## St Joseph's College Physical Education and Sports Precinct Project (PESPP) (SSD 8970)

### RESPONSE TO SUBMISSION

Prepared on behalf of St Joseph's College

13 May 2019 | 16037

MARY STREET

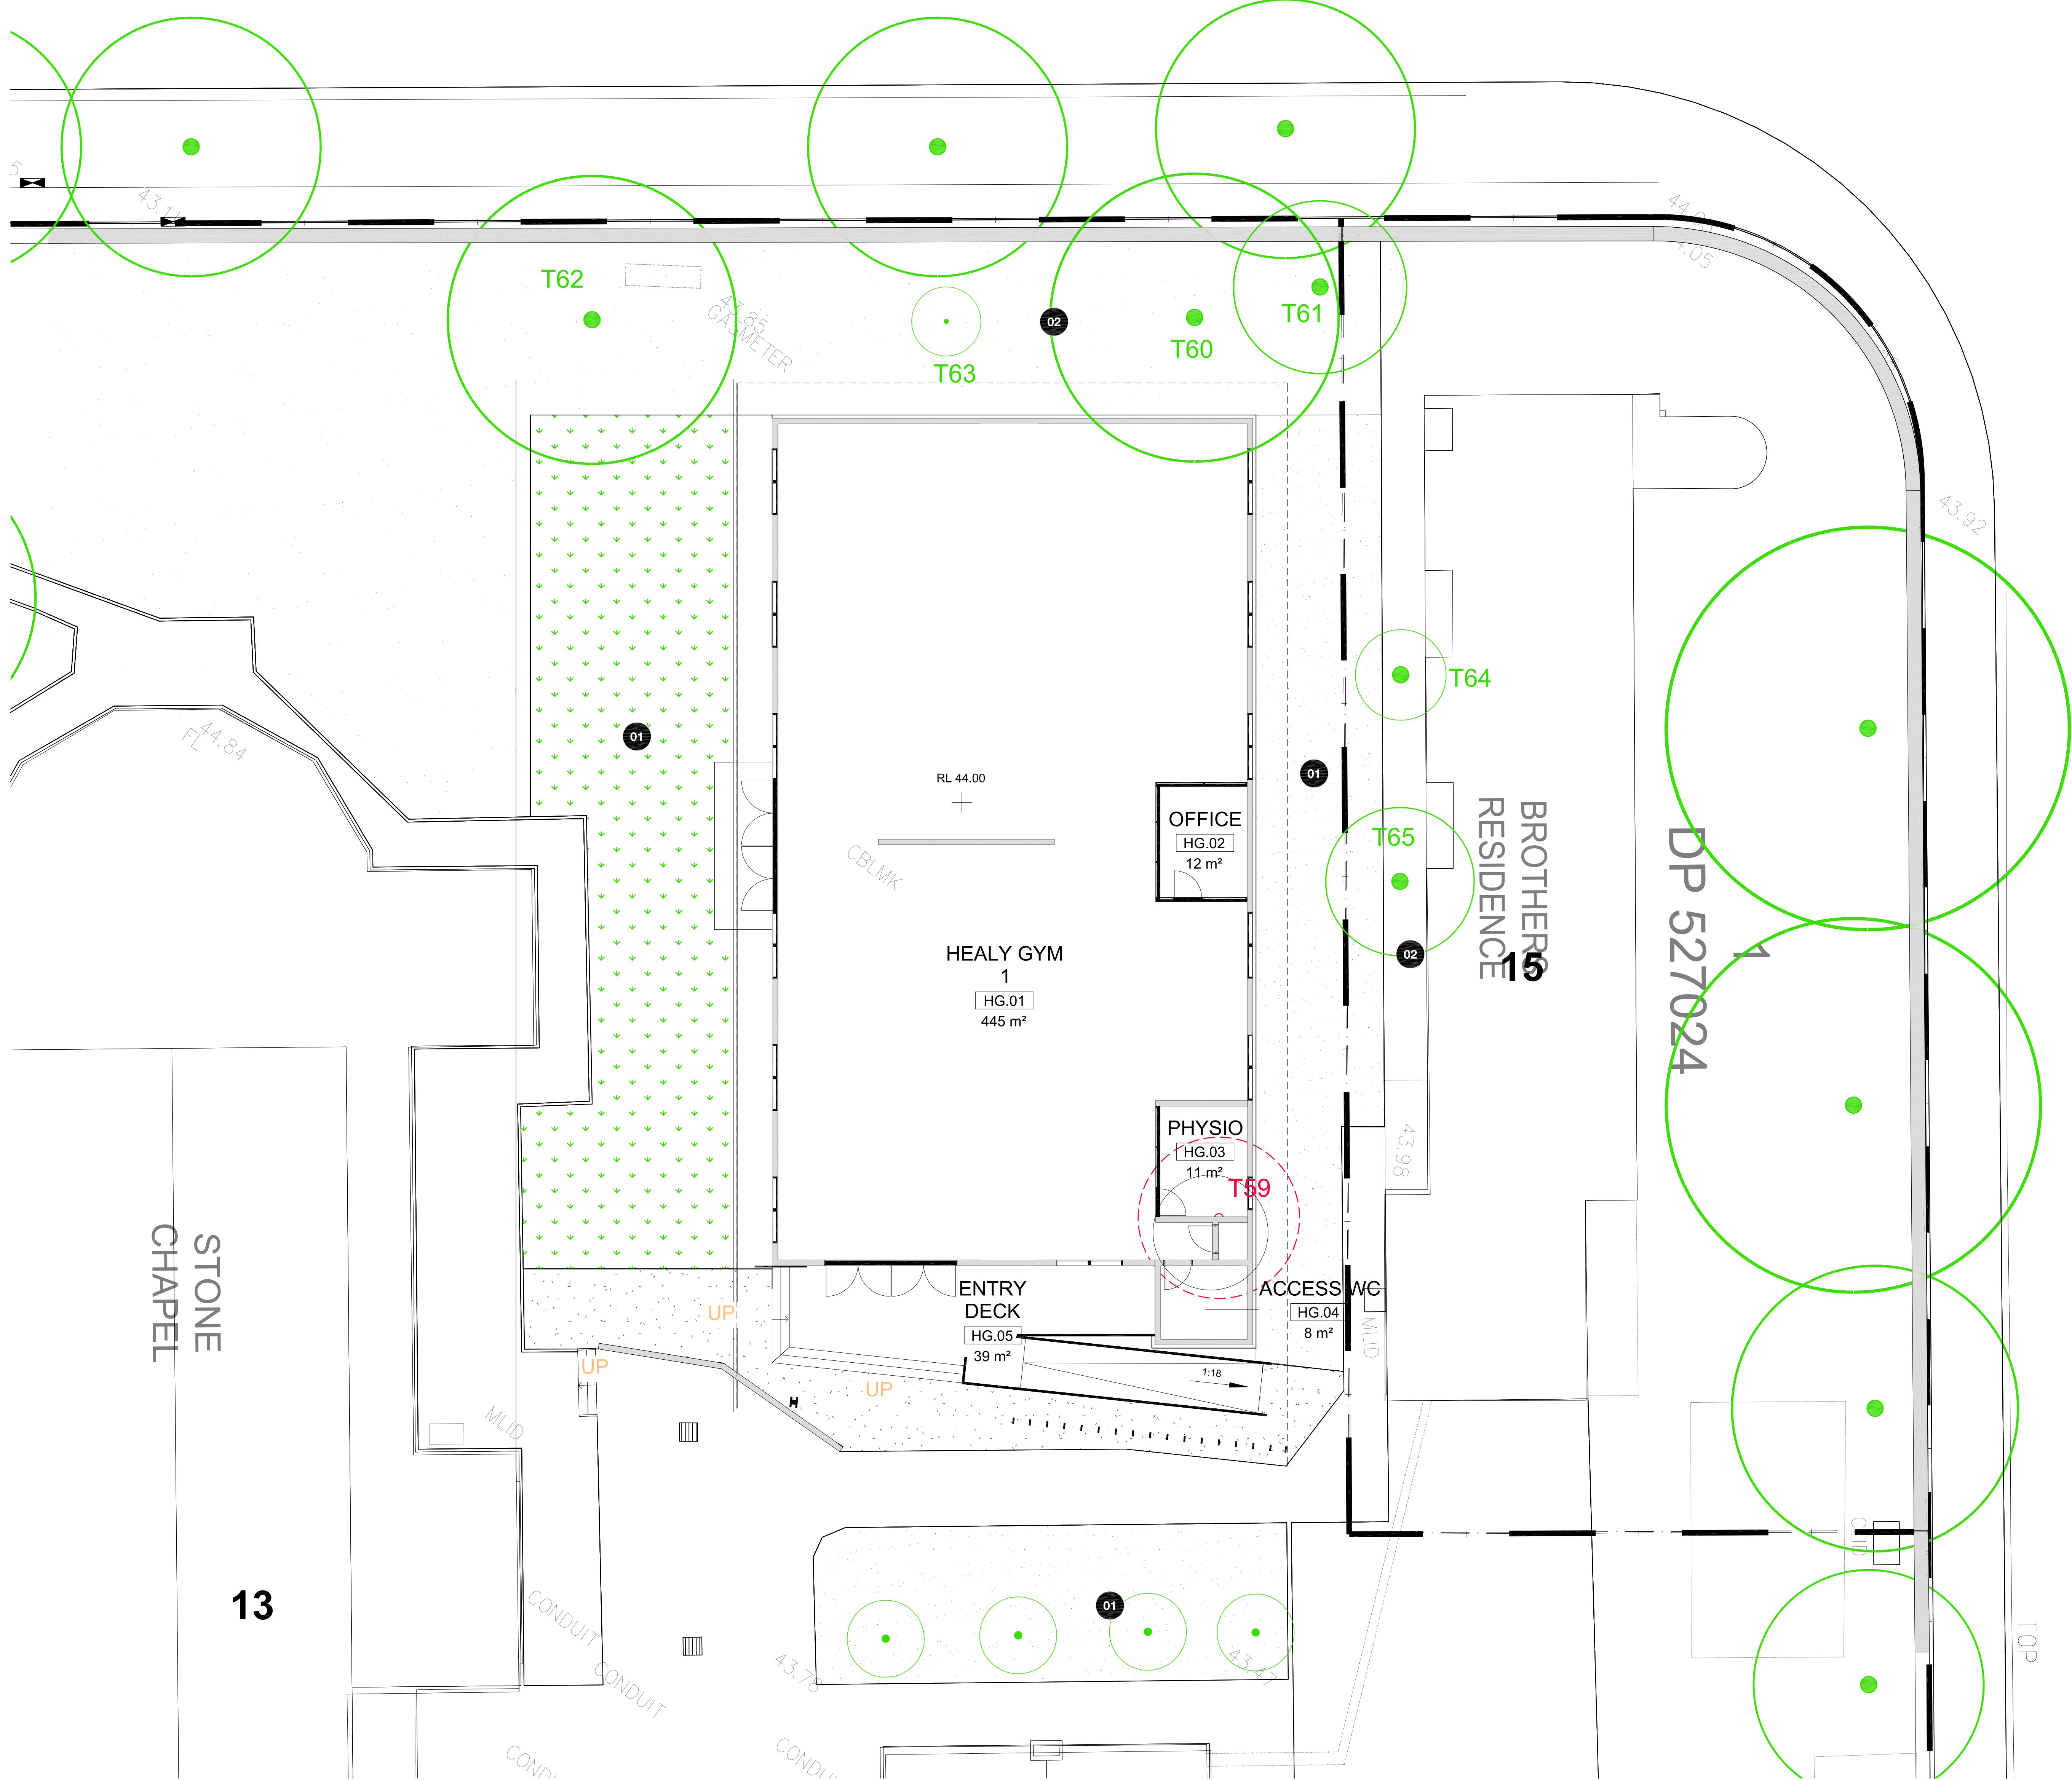
- The submitted plans do not identify the total number of individual trees that are proposed to be removed within the site and outside the boundary of the site. The Department notes that one row of trees has been counted as a single tree, which is not acceptable. Each tree should be individually identified, and the impacts of removal assessed.*

- The Department considers that additional replacement tree planting should be provided within the site, especially along the peripheries (front setback areas), to assist with screening the building and offsetting the loss of tree canopy within the site including six large trees.*

- The Department requires that a comprehensive schedule of the total number of trees that are proposed to replace the loss of tree canopy be submitted. The proposed replacement planting should comprise of native species ranging in height from 14 to 30 metres.*

- Updated landscape plans must be submitted including details of the replacement planting within the site.*

The amended Landscape Strategy (**RtS Appendix F**) and Arboricultural Impact Assessment (**RtS Appendix H**) confirm that the following individual trees are to be removed/replaced:

- Individual trees to be removed:** 16 individual trees are proposed to be removed to facilitate the proposed works (compared with 36 trees in the Original SSDA). The 16 individual trees comprise:
  - 4 High Retention Value trees
  - 6 Medium Retention Value trees
  - 6 Low Retention Value trees
- Trees to be removed outside of the site:** One tree is to be removed outside of the site (Tree 38 on Luke Street) compared with 20 trees which were to be removed in the Original SSDA
- Replacement trees within street setbacks:** A new landscaped buffer is proposed along Luke Street and Gladesville Road including 21 new trees planted on the site between the PESPP and sandstone wall (Lemon Scented Honey Myrtle (*Backhousia citriodora*), 14-30m high at maturity).
